WEST SUSSEX COUNTY COUNCIL CONSULTATION

TO:	Arun District Council FAO: Anita Gardner
FROM:	WSCC Highway Authority - Matthew Bartle
DATE:	28 October 2019
LOCATION:	Minster Court Courtwick Lane Littlehampton BN17 7RN
SUBJECT:	LU/300/19/PL Erection of four new commercial units (Use Class B1, B2 or B8), amended access & associated car parking.
RECOMMENDATION:	More information

ACCESS TRACKING

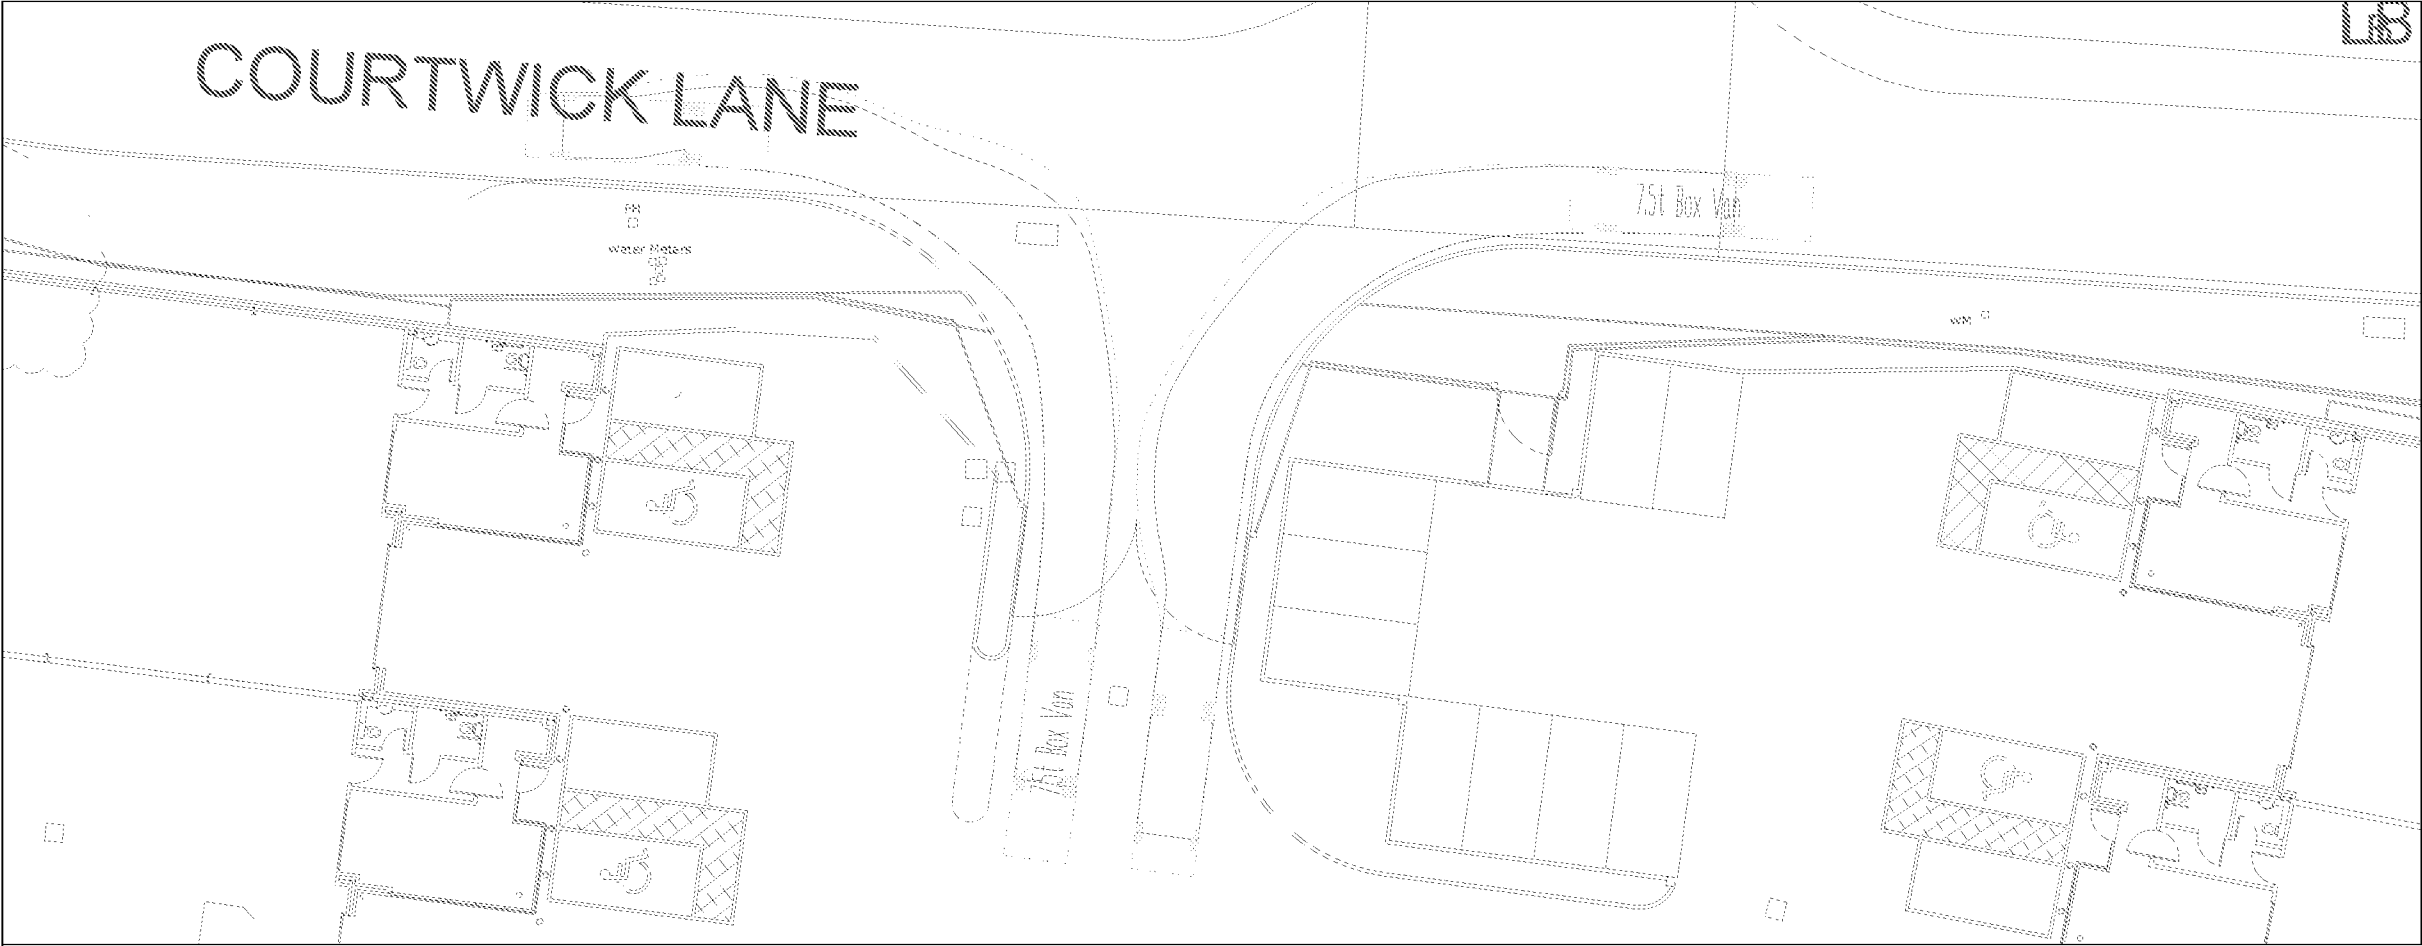
However, the applicant should provide a road safety audit and road safety audit response report for the new access, in line with the County Council's road safety audit policy at:

It would help if PDF copies of the access and tracking drawings could be provided because they have not scanned well onto the council's website and are unclear.
